TfNSW reference: STH25/00349/003

Your reference: DA1-01-200-Mod 3 (PAE-92073459)

SSD 1-01-200 - DA1-01-200 – MODIFICATION 3 – BARINA QUARRY CONTINUATION AND STOCK PILE AREA EXTENSION – MULTIPLE LOTS – 2692 COLLECTOR ROAD, GOULBURN

Transport for NSW (TfNSW) is responding to Modification 2 referred on 17 March 2025.

APPENDIX 3: PRIMARY AND SECONDARY TRANSPORT ROUTE

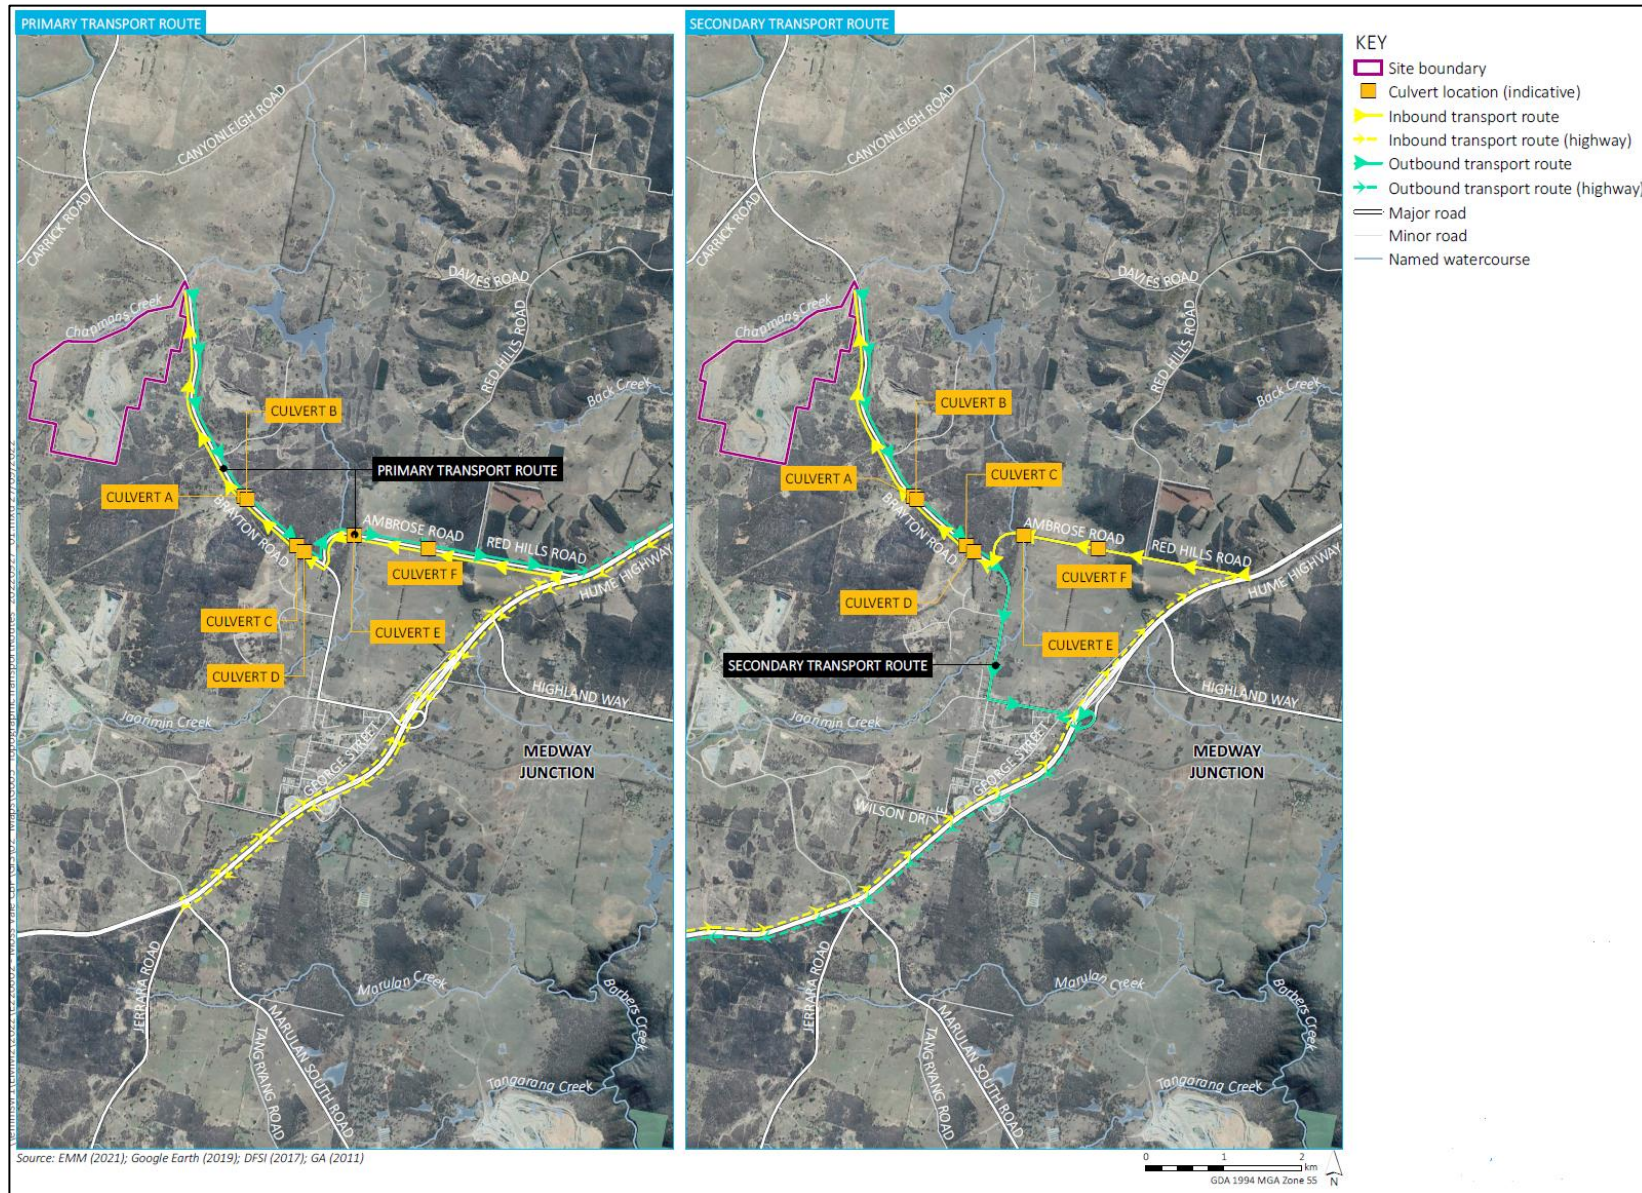
- The Traffic Management Plan (TMP) does not include details of the haulage route between the subject site and the Federal Highway. This information should be provided for each heavy vehicle classification accessing the development to ensure compliance with National Heavy Vehicle Regulator (NHVR) route restrictions.
